**Application by Norfolk Boreas Limited for the Norfolk Boreas Offshore Windfarm.
The Examining Authority's written questions and requests for information (ExQ1)
Issued on 19 November 2019**

Please find attached answers to the highway elements of your request from Norfolk County Council (NCC) in its capacity as Local Highway Authority (LHA).

ExQ1: Tuesday 19 November 2019
Norfolk County Council Responses
Identification reference: 20022890

Title:  
Bat Activity Survey locations (Map 3 of 16)

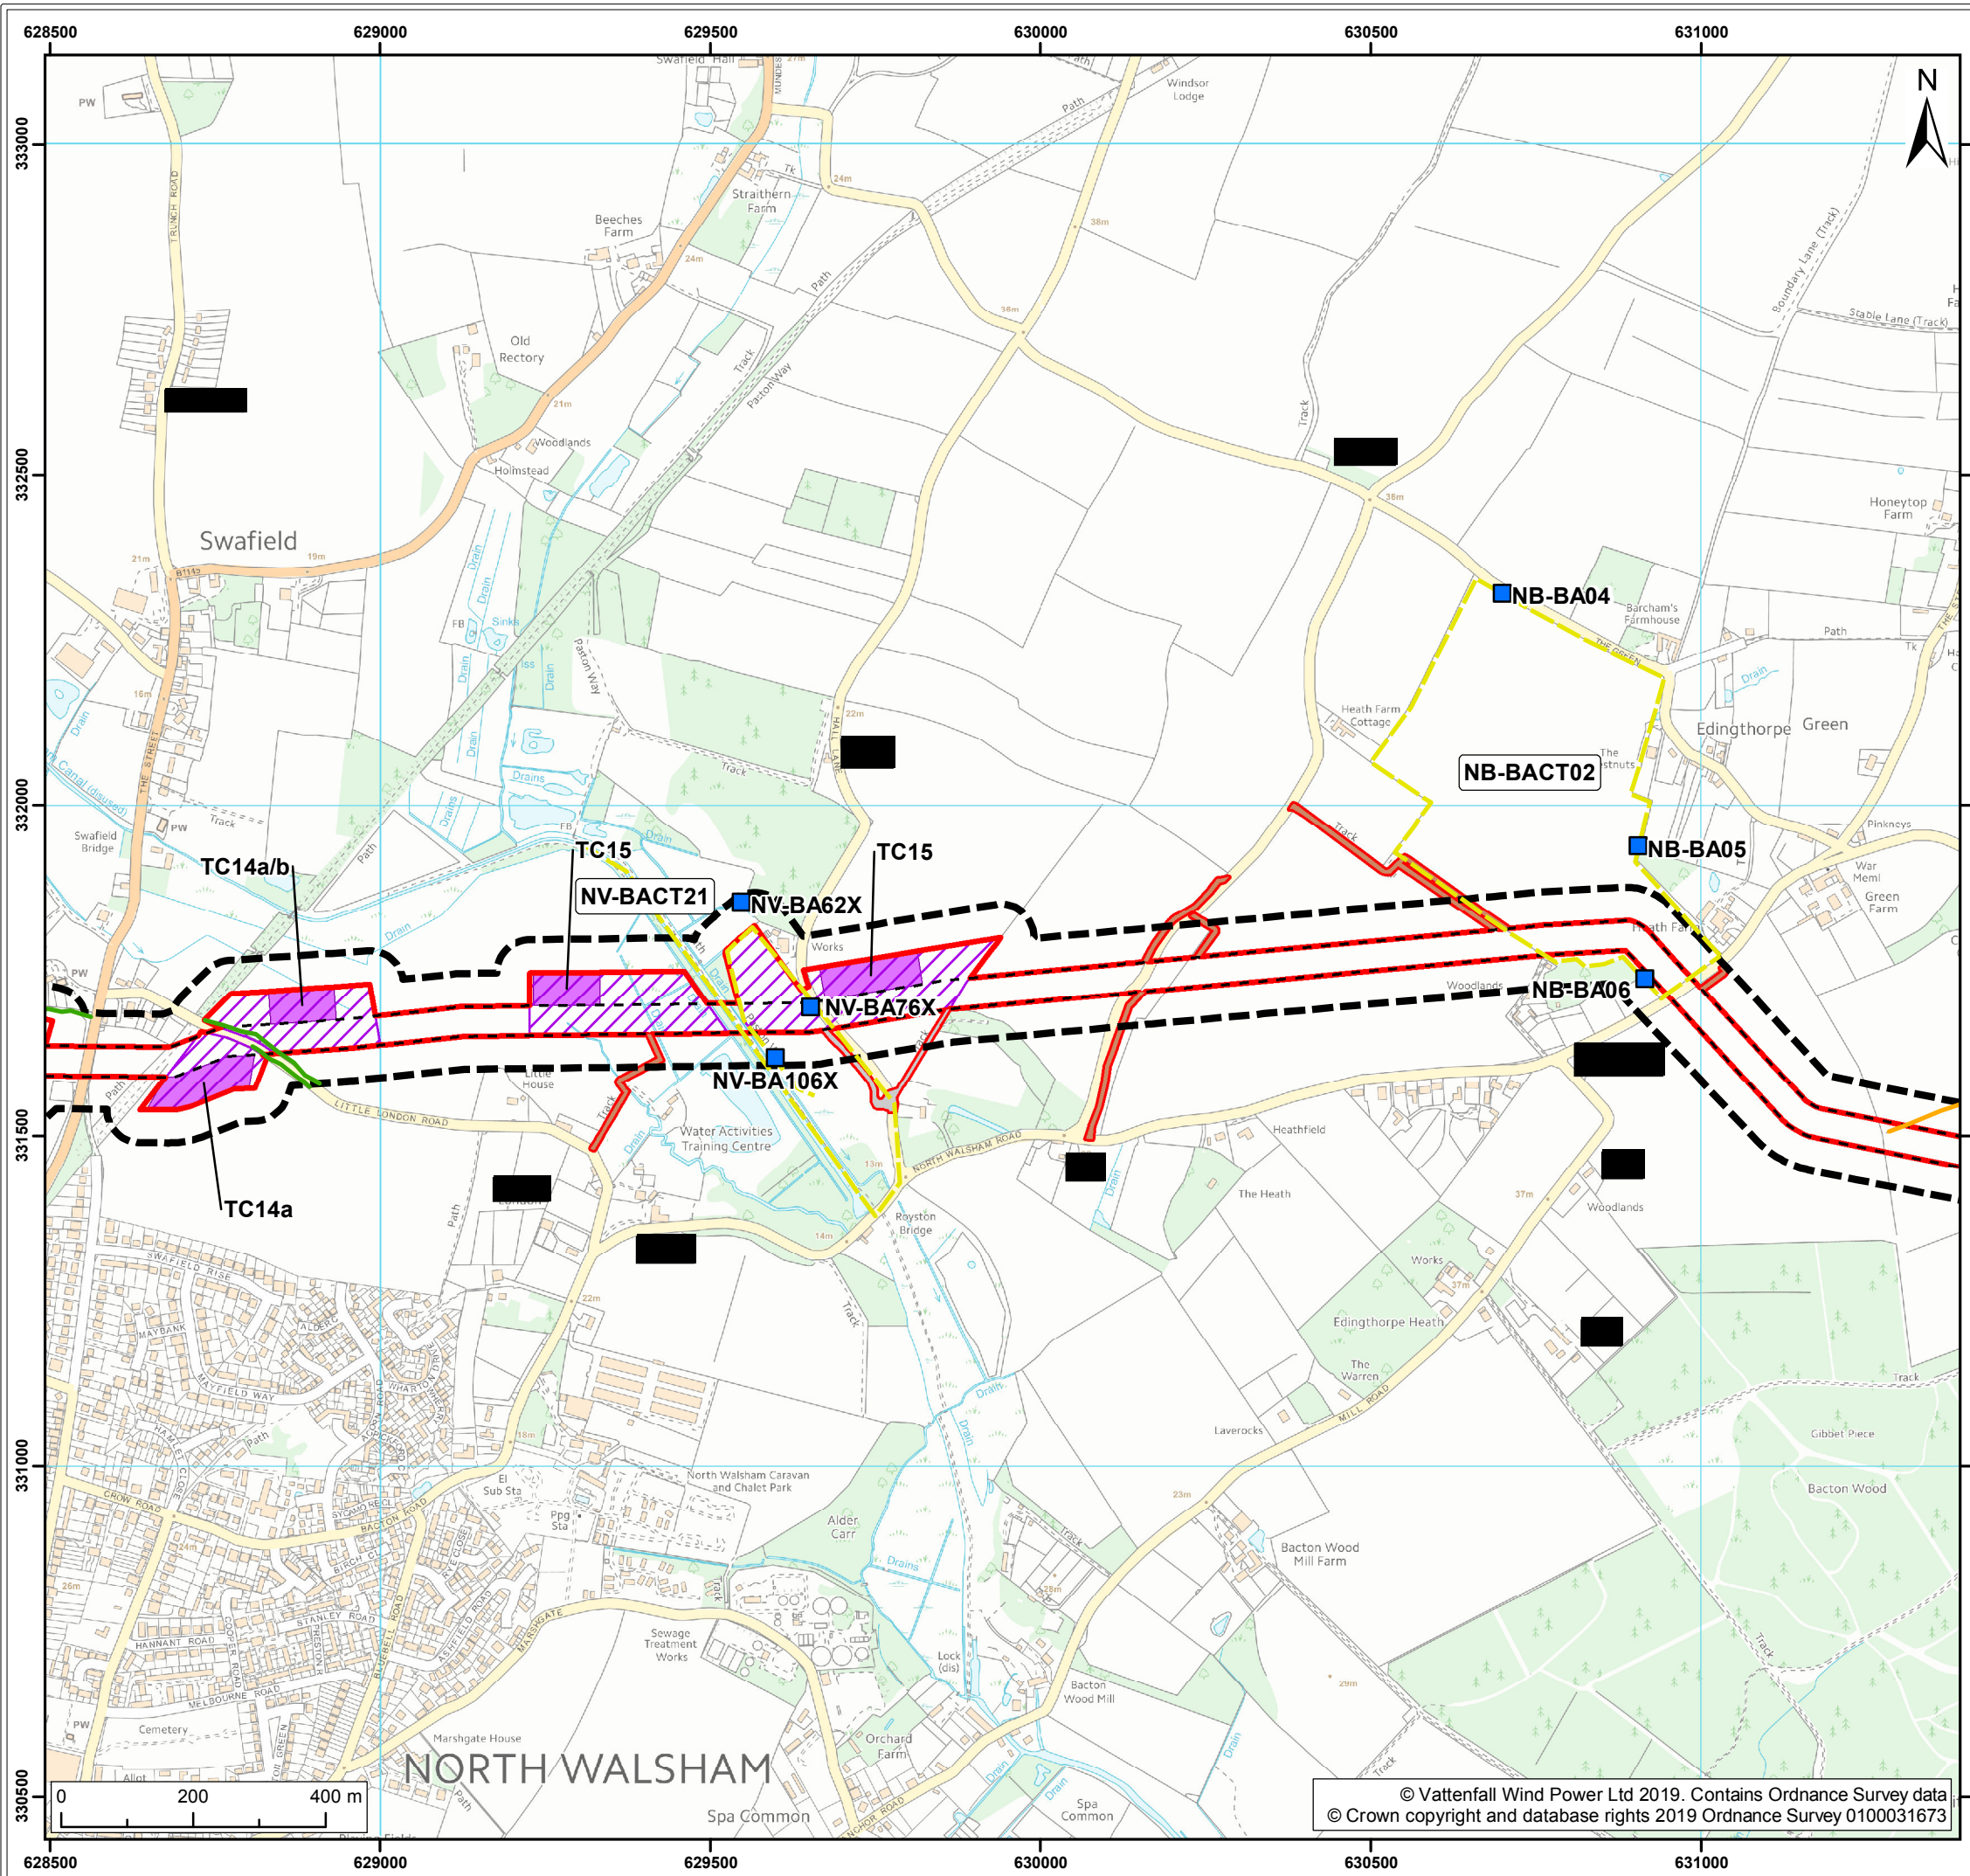
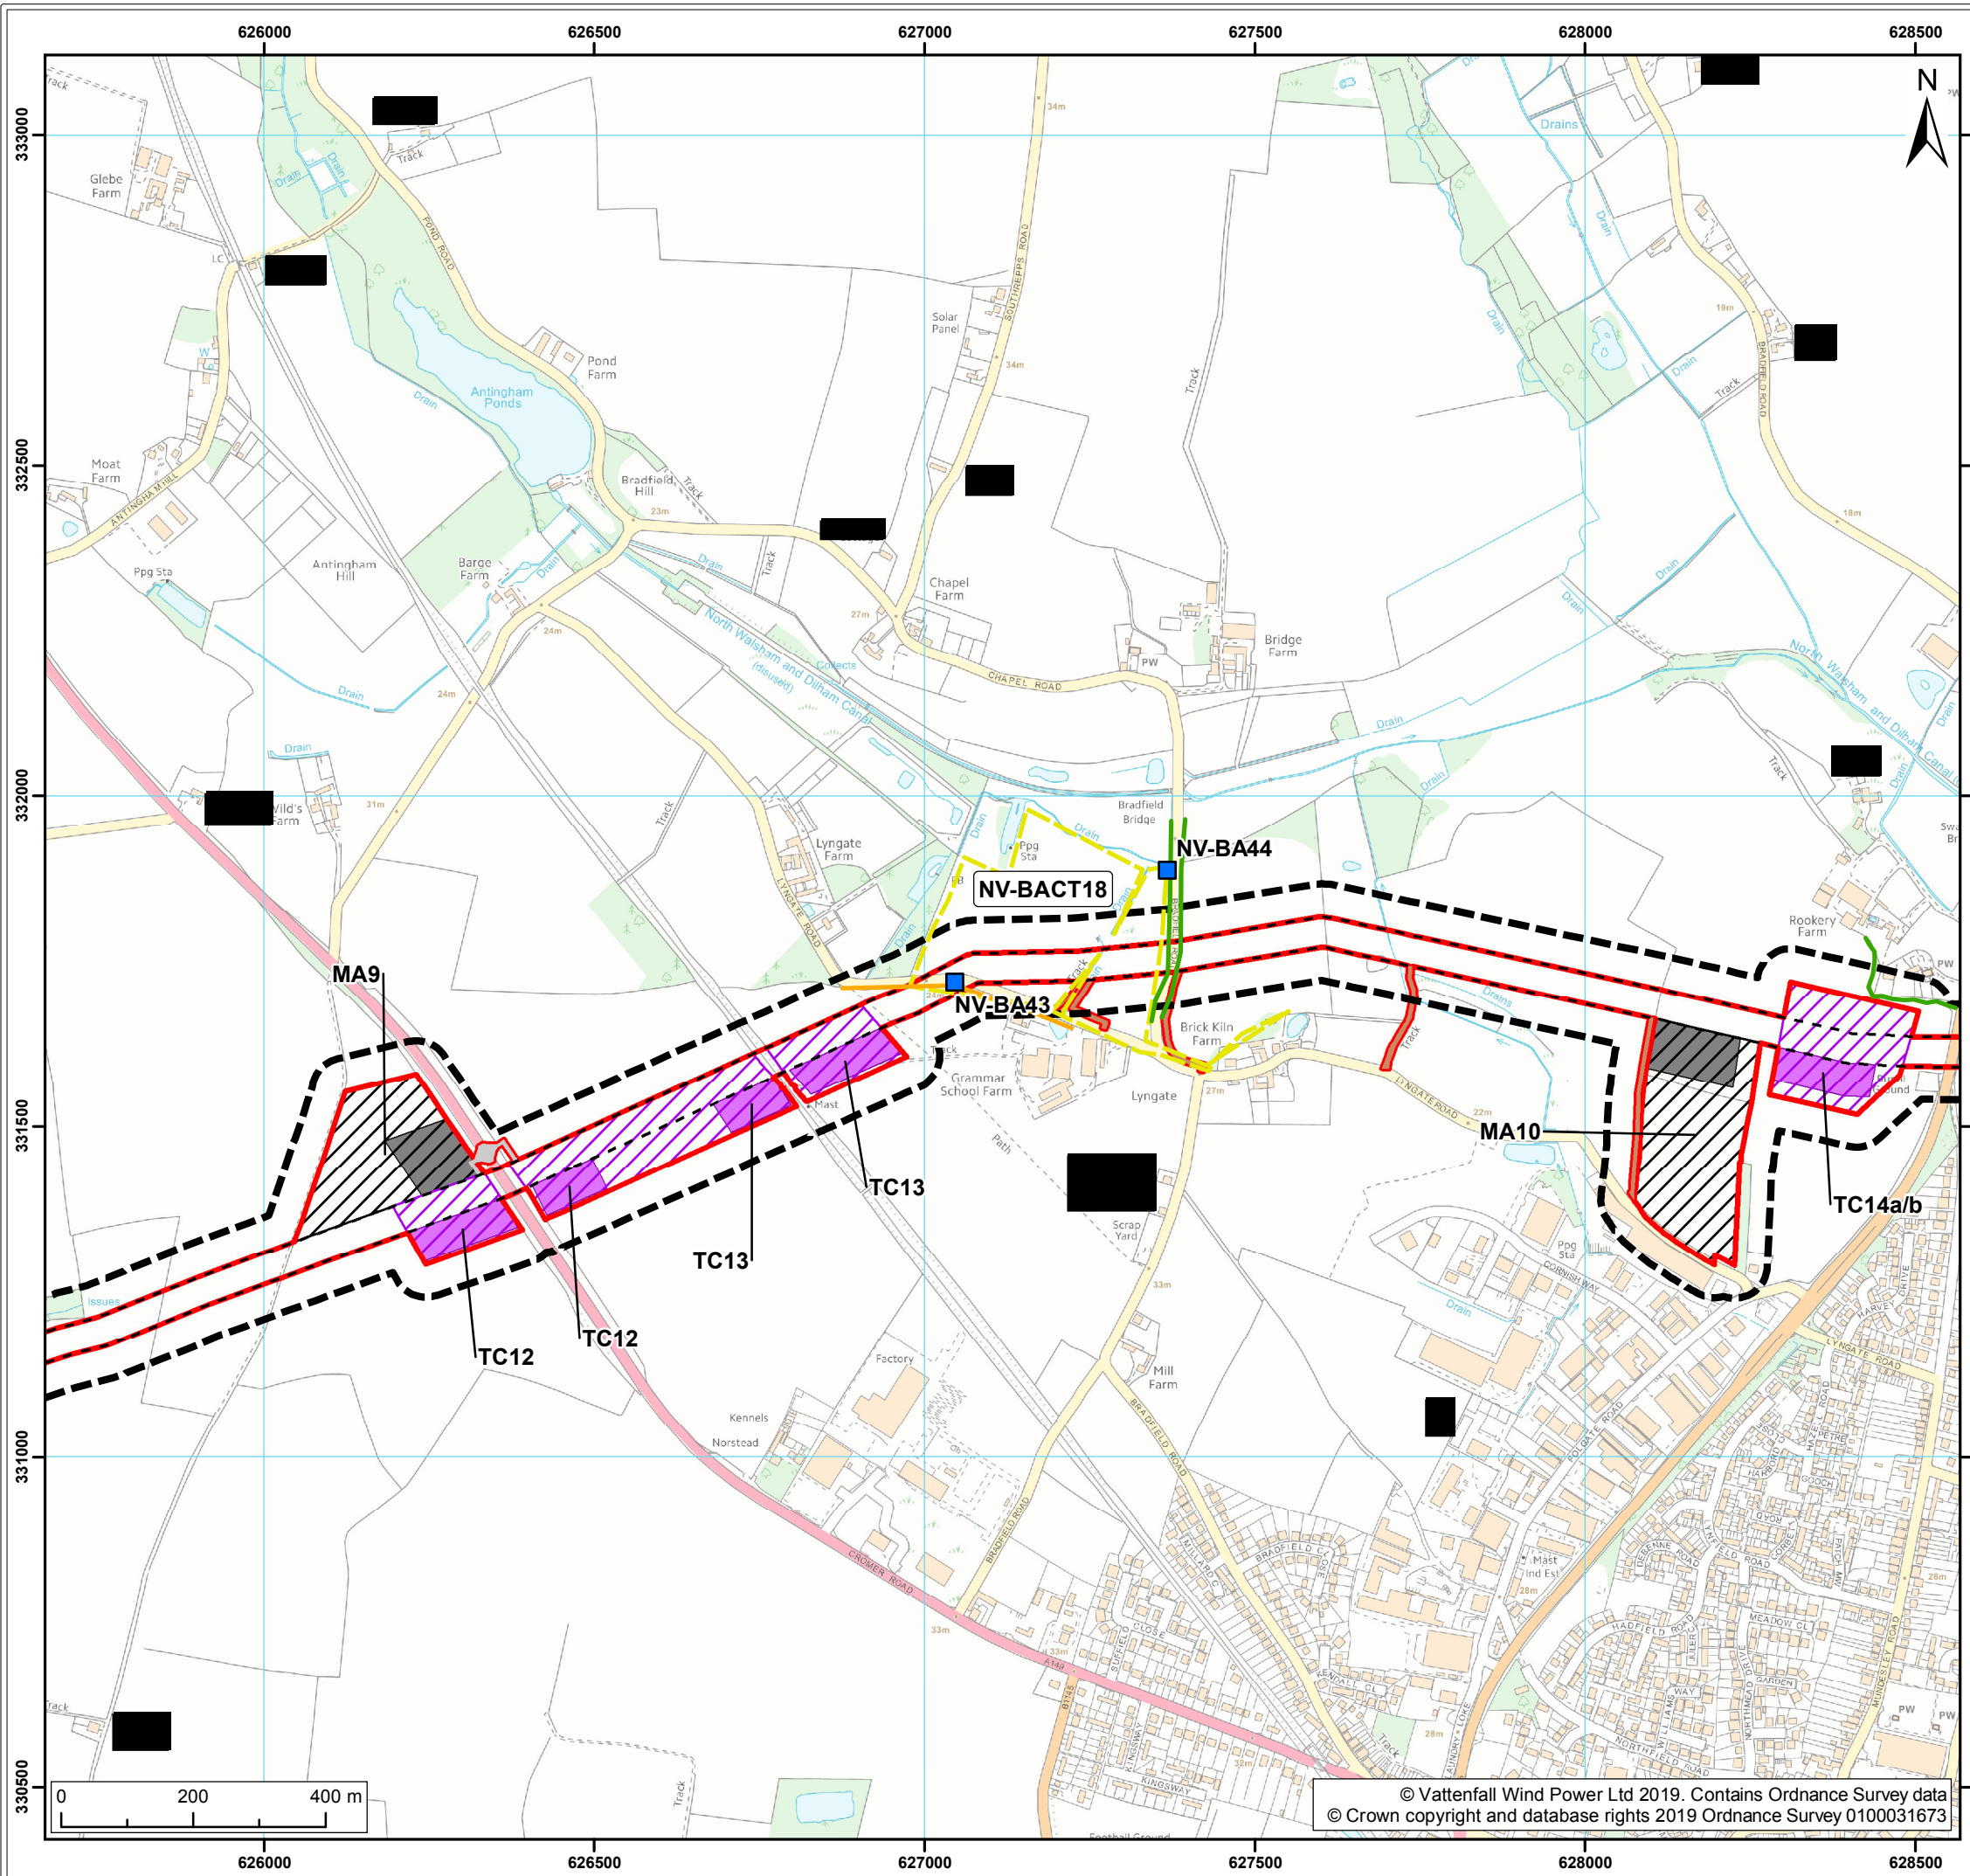
ExQ1	Question	Response
		<p>are? (Appendix 22.5² contains a report from November 2017; Appendix 22.04³ contains a report from February 2018 and Environmental Statement Figure 22.8 - Bat activity results⁴ contains maps from May 2018 showing bat activity survey locations, and Environmental Statement Figure 22.9 - Bat emergence results⁵ contains maps from dated April 2018).</p> <p>4. Table 22.9 (page 30) indicates that radiotracking data and other species roost data was obtained from Norfolk Barbastelle Study Group for the onshore project area and a 5km buffer. This is a misrepresentation as the data, notably radio tracking data, relates to Paston Barn SAC only rather than, as indicated, all barbastelle roosts within a 5km radius of buffer of the entire cable route.</p> <p>5. Table 22.21 (page 78) – hedgerow loss will be restricted to that required for access beyond the two-year duct installation phase, and will be no wider than 6 m. In Table 22.23 page 84 it says hedgerow gaps will be 13m long, possibly extending to 16.5 if crossed at an angle. Please can this be confirmed. (see Chapter 5 Project description – not reviewed at this stage).</p> <p>Comments on Assumptions</p> <p>1. Paragraph 83/84. Biological records data provided by NBIS includes records made almost exclusively by volunteers, the great majority of these data are collected by amateur experts in their field. All records provided by NBIS have a</p>
